January 6, 2020

RE: **Lot 4 Block 5, S.A.D. 227**  
**Unser Cliffs Subdivision**  
**6512 Onyx Ct. NW**  
**Grading and Drainage Plan**  
**Engineers Stamp Date 1-3-20 (E10D071)**

RE: **Lot 4 Block 5, S.A.D. 227**  
**Unser Cliffs Subdivision**  
**6512 Onyx Ct. NW**  
**Grading and Drainage Plan**  
**Engineers Stamp Date 12-23-19 (E10D071)**

Lot numbered Four (4) in Block numbered Five (5) of UNSER CLIFFS SUBDIVISION, as the same is shown and designated on the Plat thereof, filed in the Office of the County Clerk of Bernalillo County, New Mexico, on August 12, 2004, in Book 2004C, Page 238, as Document No. 2004114456.

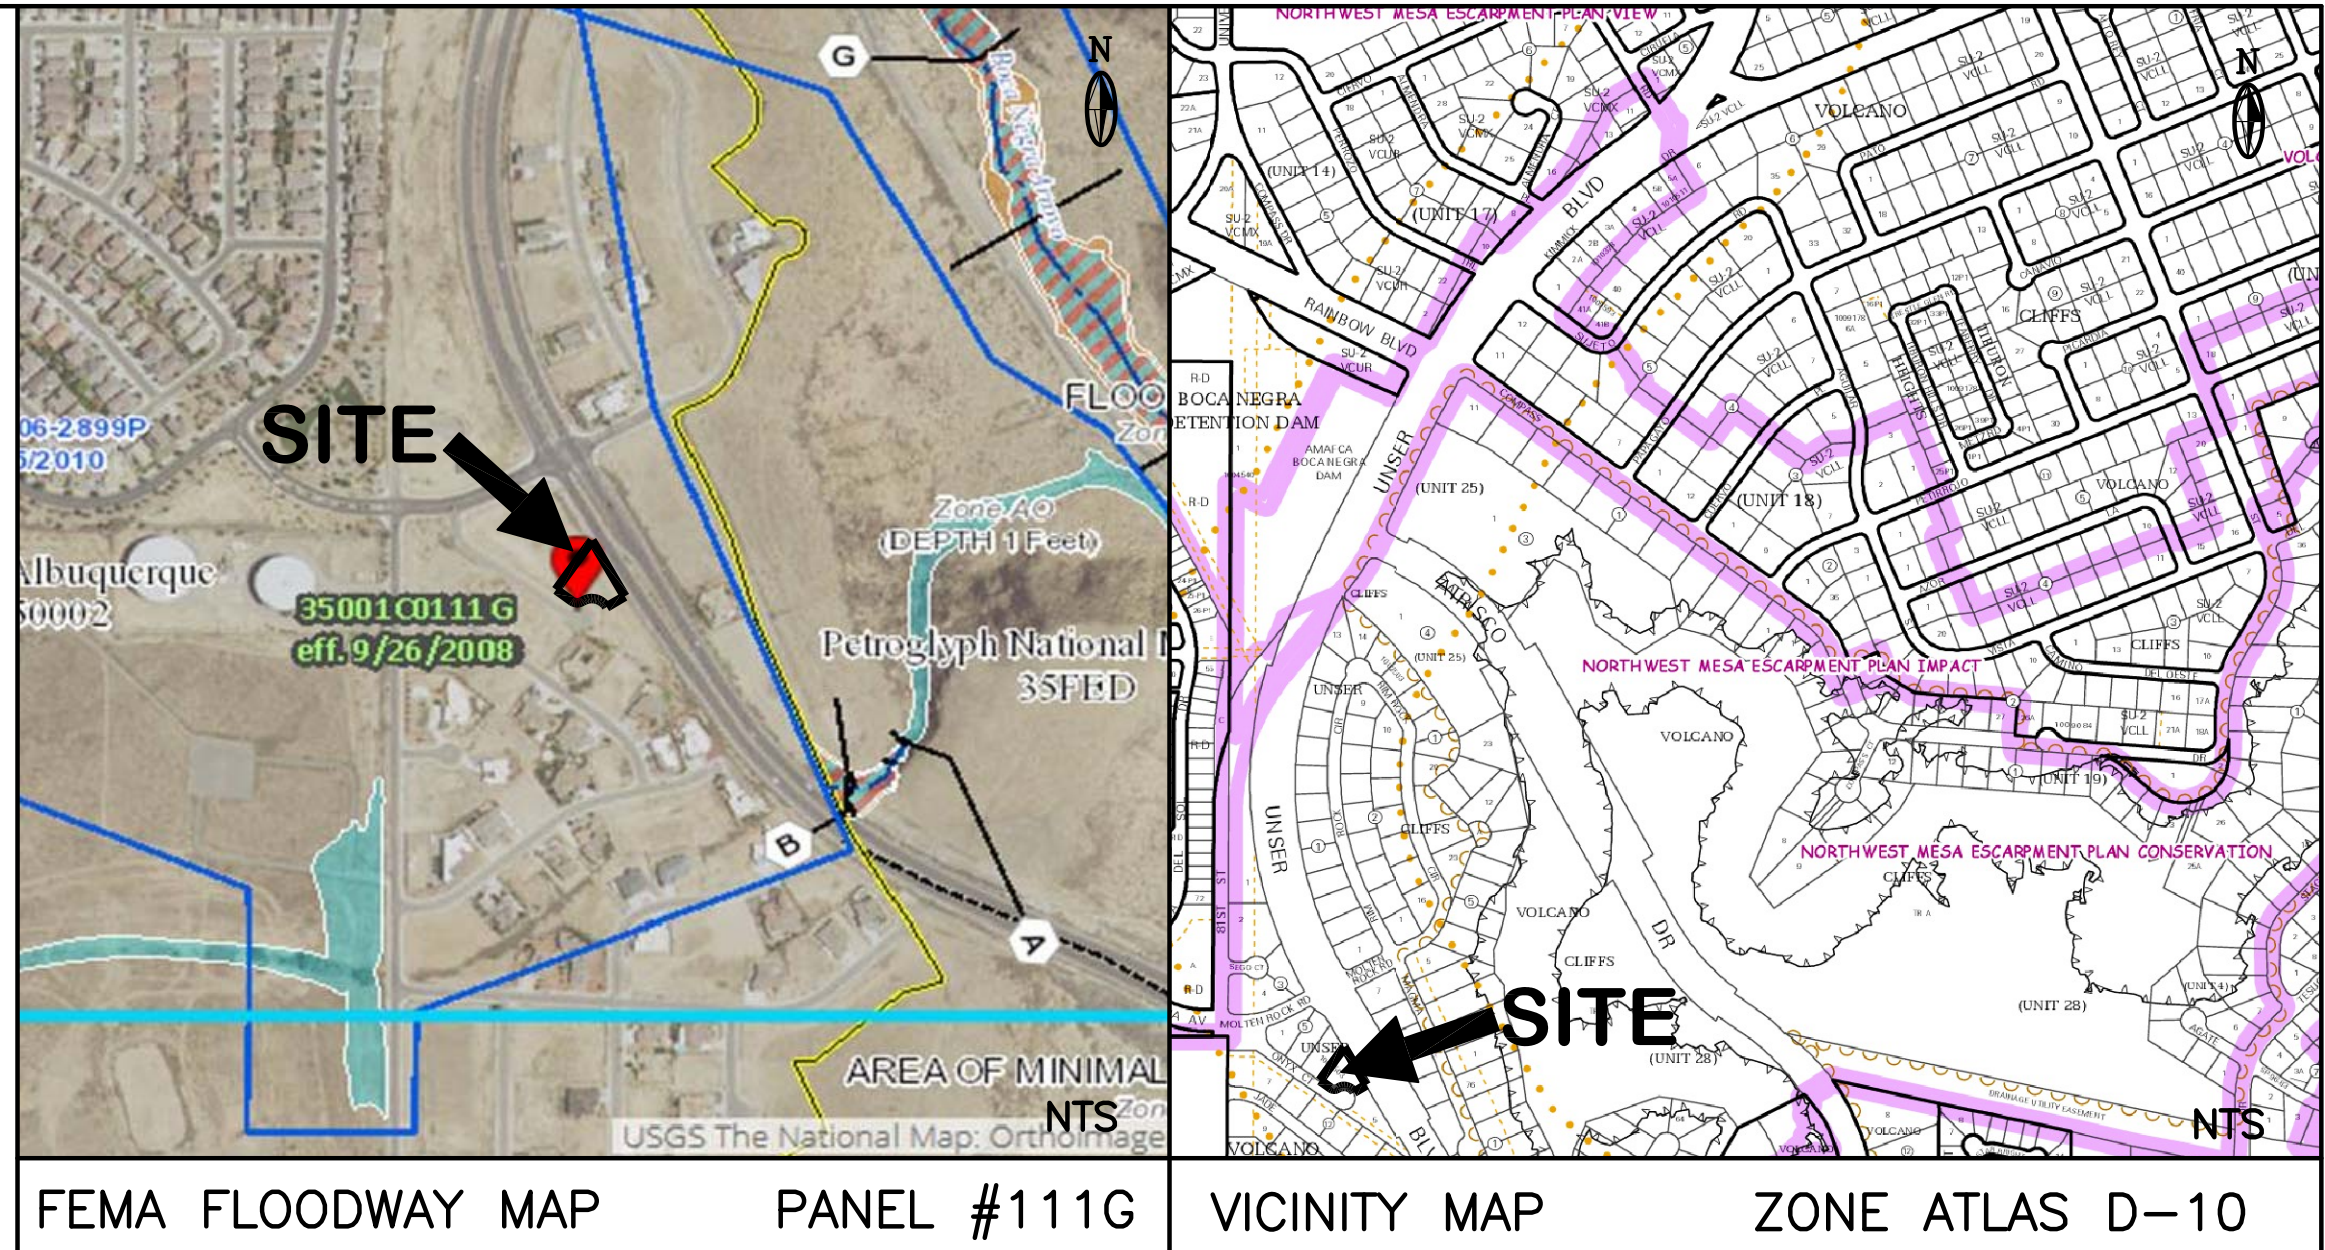
- Direct all flows to exit onto Onyx Ct. through a sediment capture pond. **OK- revised**
- Cross lot drainage is not required; remove the turn blocks on the eastern garden wall. **OK- revised**
- Provide a percentage for land treatment C. **OK - revised**
- Notify the owner/contractor not to use dirt as a ramp to climb the curbing, may use lumber or crusher fines for this function. **The owner is copied with this response.**
